Recommendation Report for Planning Permission for Works or Extension to a Dwelling

REF NO: WA/91/17/HH

LOCATION: 9 Orchard Way
Fontwell
BN18 0SH

PROPOSAL: Single storey rear extension with flat roof & small mansard roof & replace flat roof over garage with pitched gable ended roof with barn end (resubmission following WA/60/17/HH).

Proposed South Elevation
Proposed Front Elevation

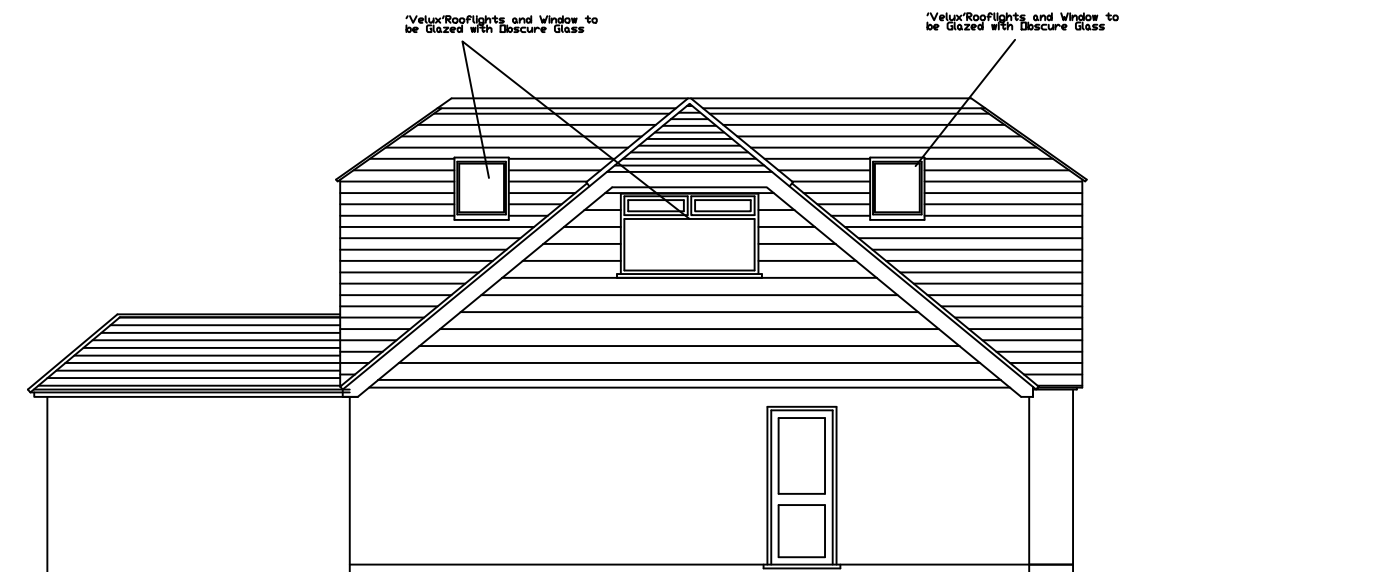
The extension over the garage will be visible fom the street scene and whilst it comprises a significant change to the character of the existing property it is considered to have an acceptable impact on the character and appearance of the locality. This is due to there being dwellings with similar properties in the area, including 10 Orchard Way and 6 Orchard Way. As such the proposal is deemed to be in keeping with the established chatacer of the area with the proposed materials to match the existing dwelling,

Proposed East Elevation
Proposed Neighbour Side Elevation

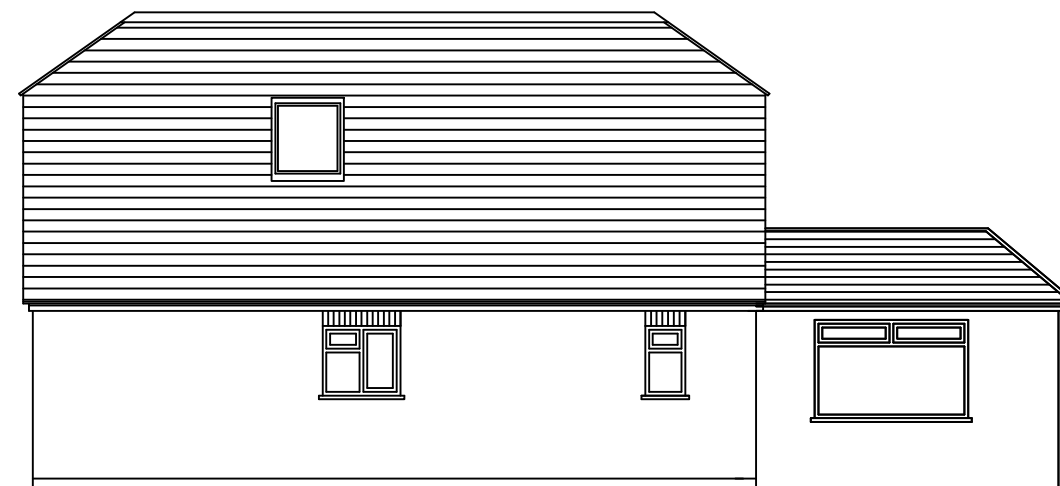
Due to the addition of a window on the East side of the property and two skylights, there is potential for overlooking into the property at number 7 Orchard Way. However, it will be conditioned that the windows on the East elevation will be obscure glazed and non-opening under 1.7m. The proposed rear extension is largely replacing a single storey one that already exists, so there is not deemed to be a significant change in the impact on neighbouring residential amenity.

Reason: To comply with Section 91 of the Town and Country Planning Act 1990 (as amended).
- 2 The development hereby approved shall be carried out in accordance with the following approved plans:
 - Elevations - 4th August 2017 - 1710221/PL/1
 - Floor & Roof Plans - 4th August 2017 - 1710221/PL/3
 - Elevation - 4th August 2017 - 1710221/PL/2
Reason: For the avoidance of doubt and in the interests of amenity and the environment in accordance with policy GEN7 of the Arun District Local Plan.
- 3 The two velux windows and dormer window in the Western elevation of the building shall at all times be and remain glazed entirely with obscure glass and non-opening under 1.7m.
